Rezoning Transportation Analysis

Petition Number: 2025-009

From: Jake Carpenter, PE

Exhibit A

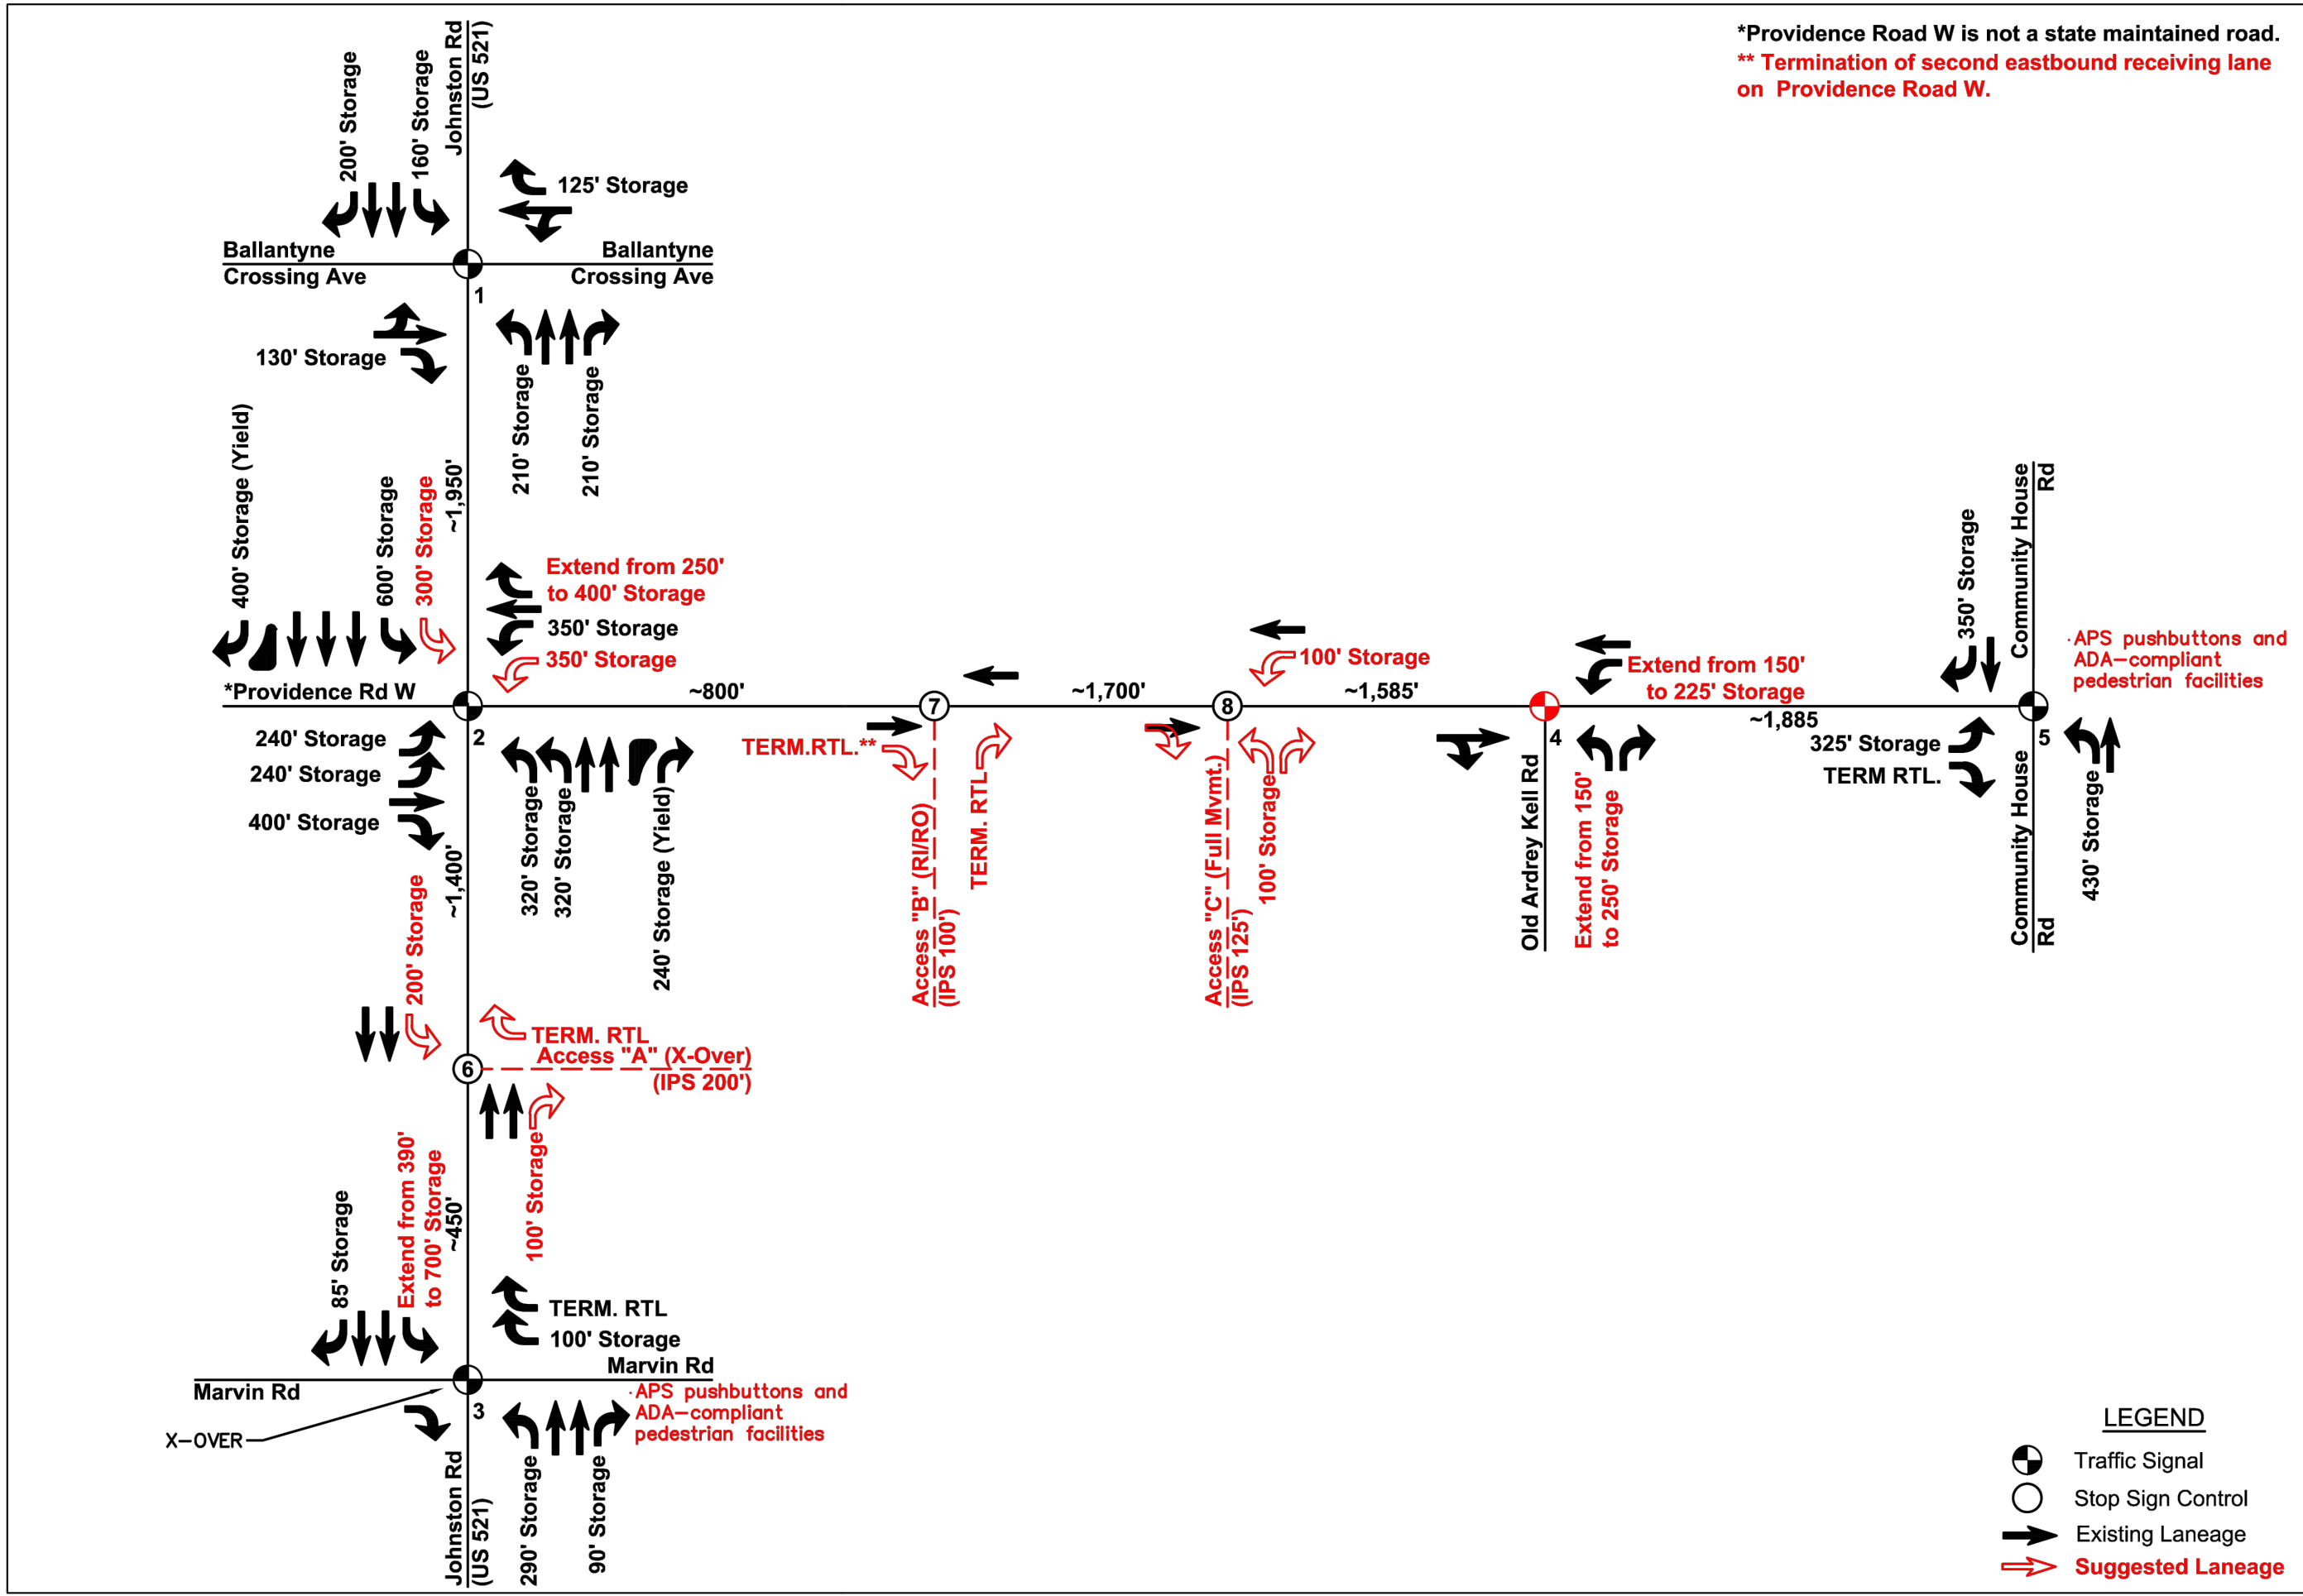
~~Clarifying Comment: 7.24.2025: update the site plan and exhibit A to show the new leftover per updated TIS at Access "B".~~

~~Outstanding Comment: 8.27.2025: update Exhibit A on sheet 2 with the approved TIS information showing the modification to Access "B".~~
